Please ask for: Ms Iqraa Malik
Email: iqraa.malik@terraquest.co.uk
Telephone: 0121 234 1390
Our Ref: FP/251/21/PL
Your Ref:
Date: 4th January 2022

Application for Planning Permission

Development: Erection of single storey rear extension following the demolition of existing lean to.
Location: 5 Davenport Road Felpham PO22 7JP

DATE	REVISION	BY
5 Davenport Road Felpham Bognor Regis West Sussex PO22 7JP		
DRAWN RD	CHECKED	
SCALE 1:50	DATE 01.01.22	
PROJECT TITLE Proposed Extension to 5 Davenport Road		
DRAWING TITLE Existing Ground Floor Plan		
DWG NUMBER 001		REV
NEG NUMBER

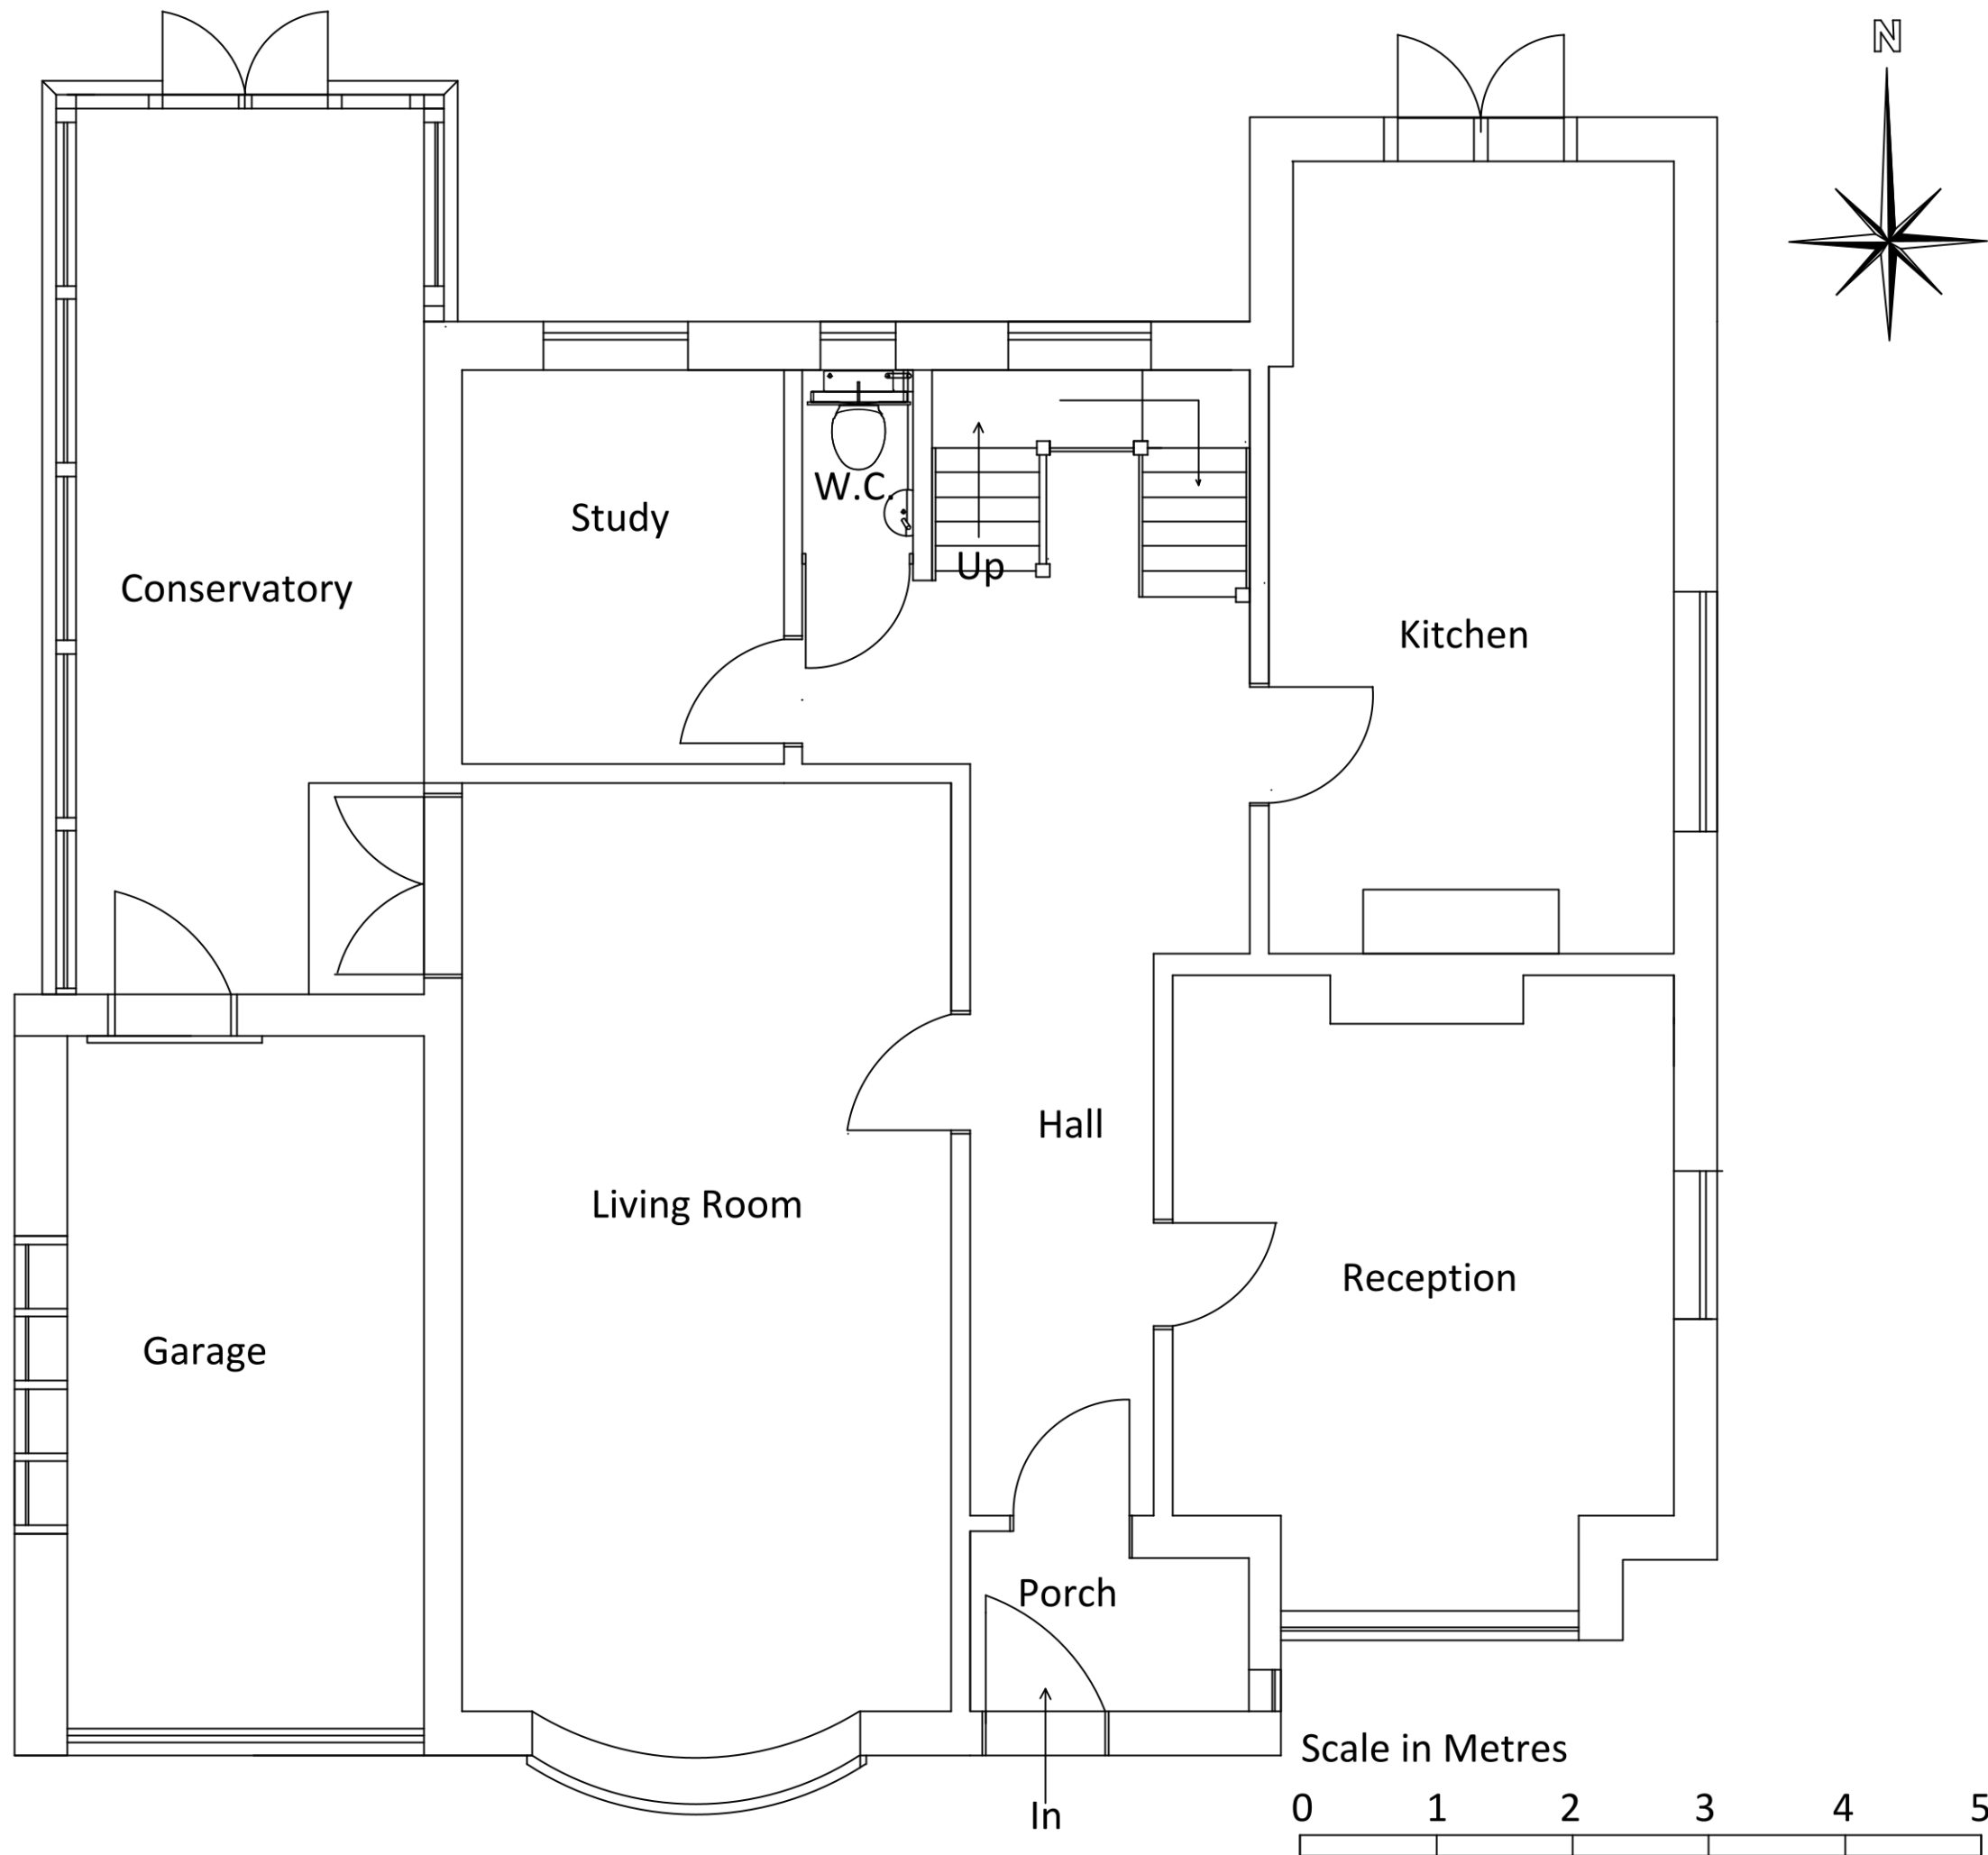
Please submit clearly labelled existing floor plans and elevations at a scale of 1:50 or 1:100. Further details can be found in the Validation Requirements List.

LOCATION PLAN

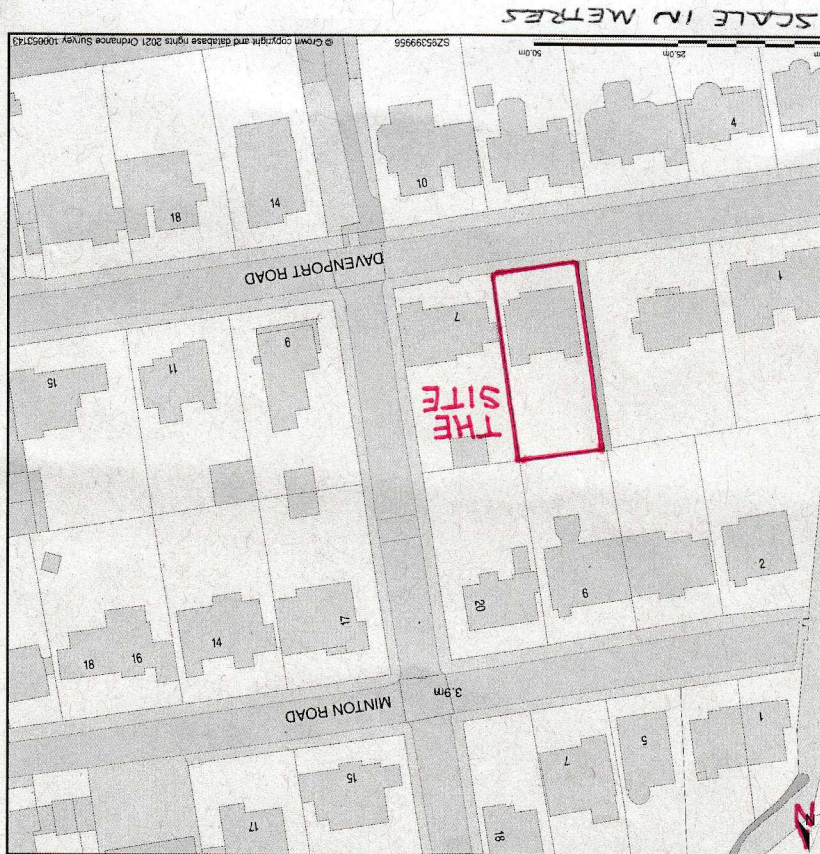
The location plan requires a solid red outline around the site boundary. Further details of what must be included on the plan can be found in the Validation Requirements List.

DATE	REVISION	BY
5 Davenport Road Felpham Bognor Regis West Sussex PO22 7JP.		
DRAWN RD	CHECKED	
SCALE 1:50	DATE 06.01.22	
PROJECT TITLE Proposed Extension to 5 Davenport Road		
DRAWING TITLE Proposed East Elevation		
DWG NUMBER 007	REV	
NEG NUMBER

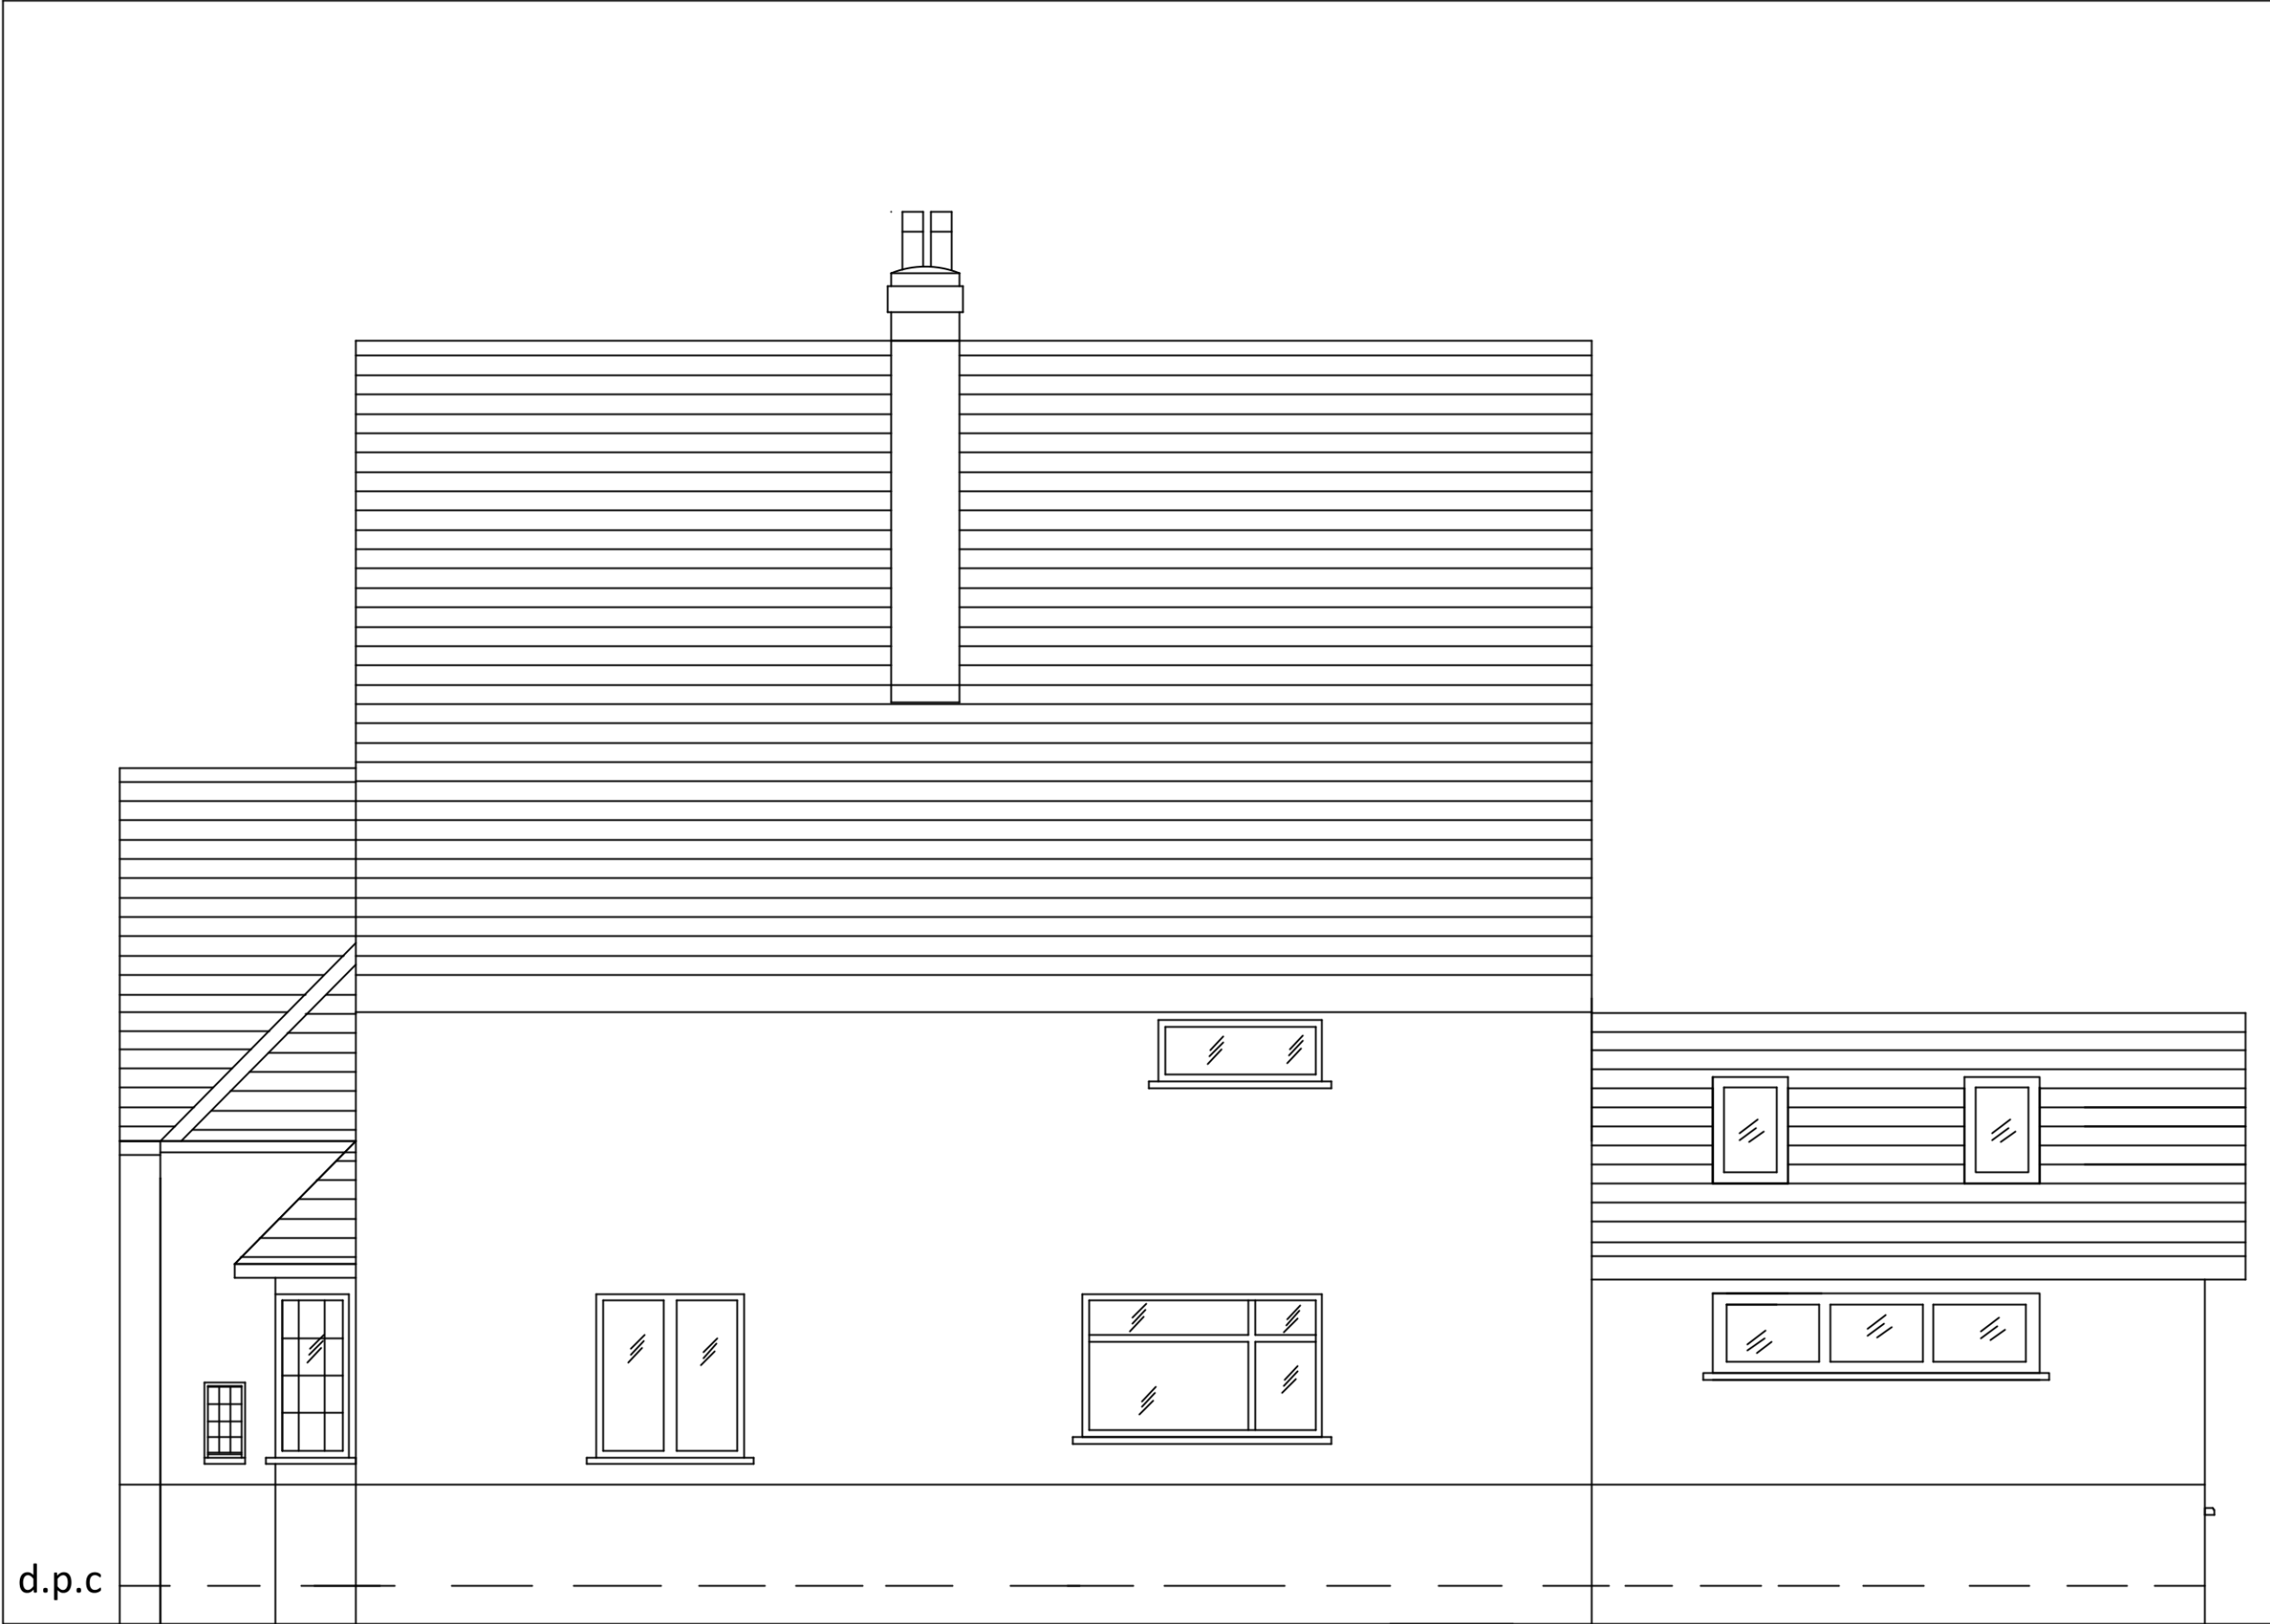
Please submit proposed elevations at a scale of 1:50 or 1:100. Along with this, the proposed floor plans require a stated scale. Further details can be found in the Validation Requirements List.
